Addendum No. 1

RE: Contract # C203993

Tyrrell-Dare Counties (B-5936)

Bridge #7 Over Alligator River On US-64

SHEET 2 OF 2

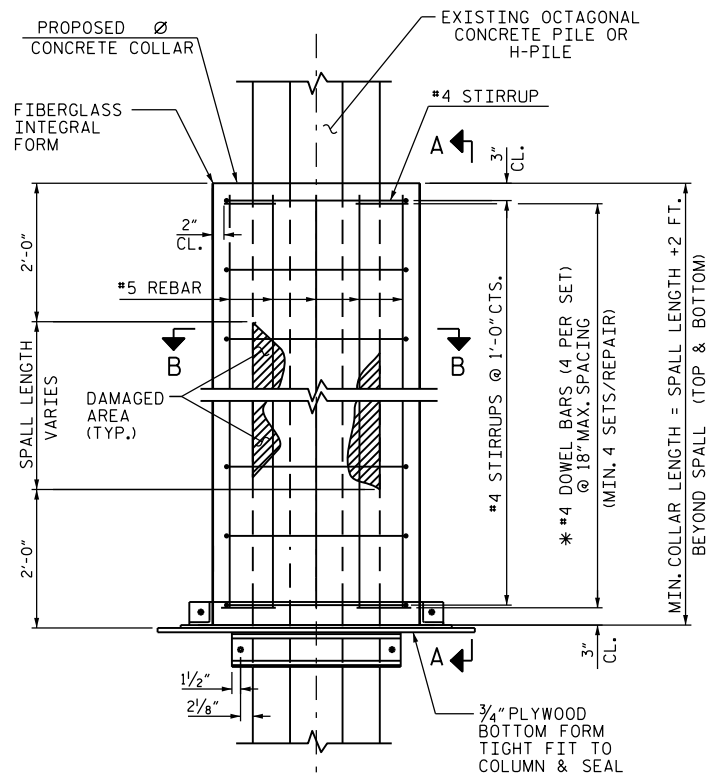
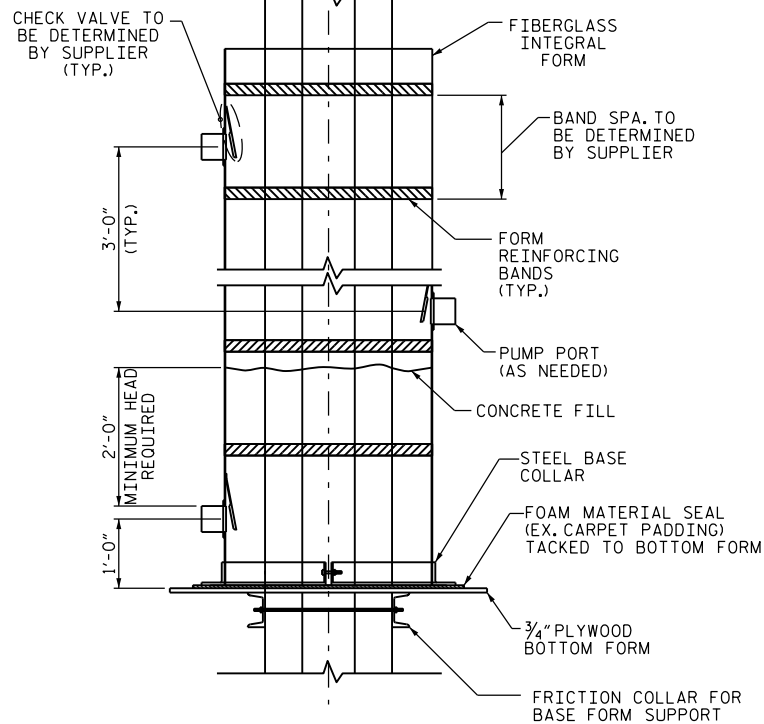
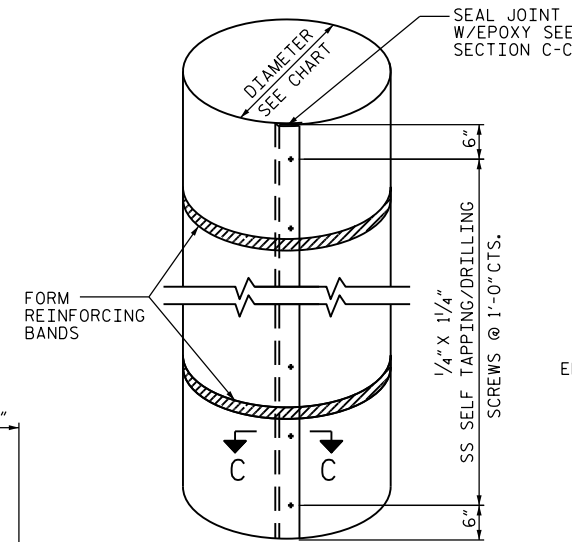
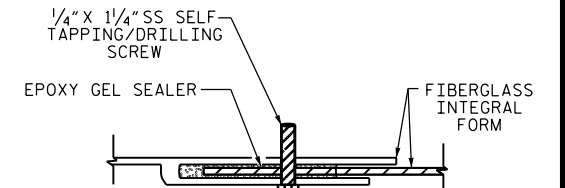
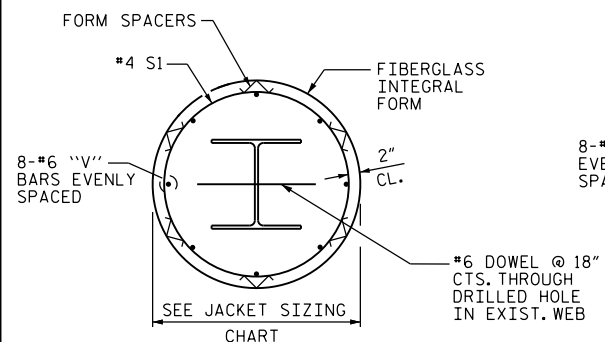
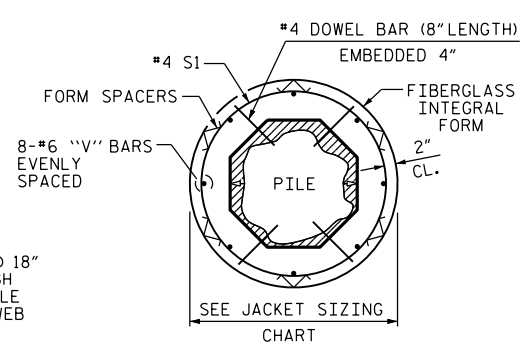
Sheet No.	Revisions
S-1	Revised to add "Asbestos Assessment" to the "Total Bill of Materials"
S-5	Revised to add note concerning "Asbestos Assessment"
S-390	Revised to correct the dowel spacing for the prestressed pile jackets to the intended maximum 6'-0" spacing
S-391	Revised to correct the dowel spacing for the prestressed pile jackets to the intended maximum 6'-0" spacing
